Planning - Case Comments

Project Number: PR-2024-009765

Application Number: SI-2024-00468

Project Name: Request: 1100 Woodward Pl. NE

Mountain Rehab Hospital Mountain Rd. / I-25	DRAWN BY DM
LANDSCAPE IRRIGATION	DATE 4/23/2025
TIERRA WEST, LLC	
5571 MIDWAY PARK PL NE ALBUQUERQUE, NEW MEXICO 87109 (505) 858-3100 www.tierrawestllc.com	SHEET # L2
Proj. No. 2024-035	JOB # 20231213

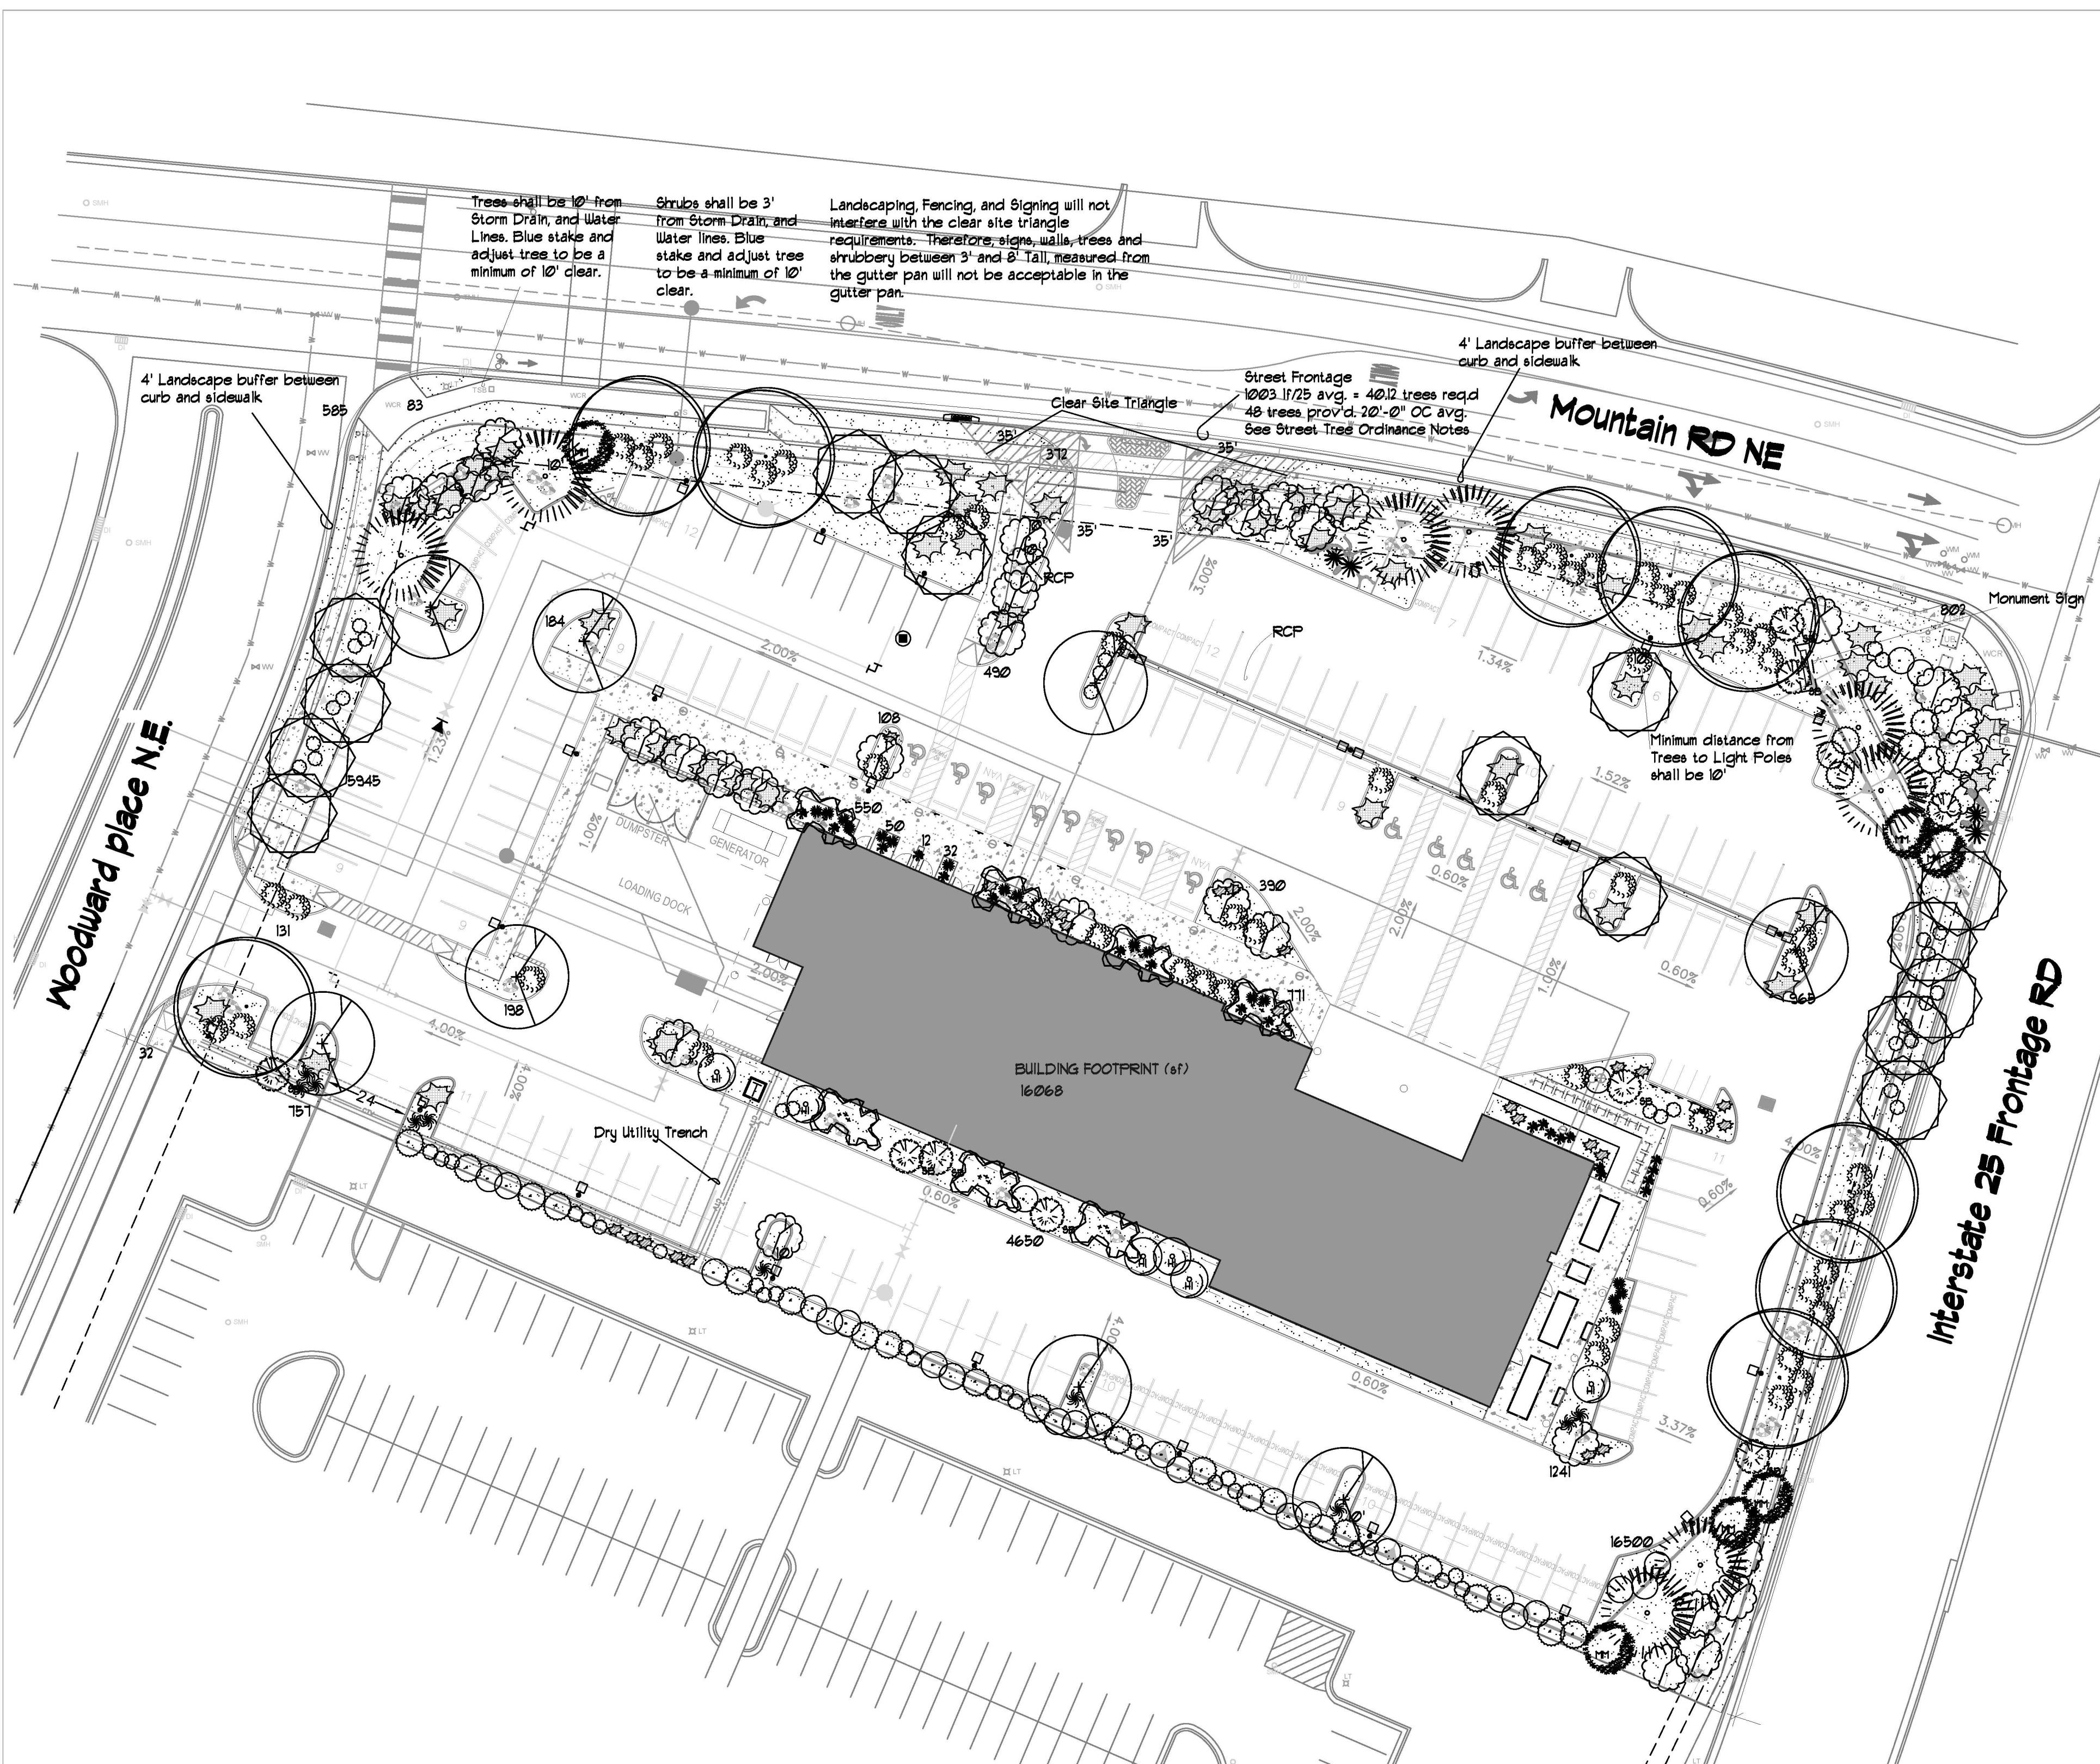
- Clarify Landscaping calculations and how the plan is meeting each relevant section of IDO section 5-6

Similar to the elevations, the Landscaping Plan needs to clarify and detail how it is meeting the requirements. Such as IDO sections 5-6(D) *Street Frontage Landscaping*, 5-6(D)(2) *Additional Frontage Landscaping*, 5-6(F) *Parking Lot Landscaping*, 5-6(F)(2) *Parking Lot Interior*, 5-6(G) *Screening Of Mechanical Equipment And Support Areas*.

- *Landscaping Plan needs to include measurements. Such as setback, buffer areas, Screening, Etc.; Several sections related to new development – 5-6-C General Landscaping, 5-6-C-2 Minimum Landscape Area, 5-6-D Required Street Trees, 5-6-F Parking Lot Landscaping, 5-6-G Equipment/Support areas*
**Notes should also directly demonstrate/explain compliance with all sections within 5-6.*
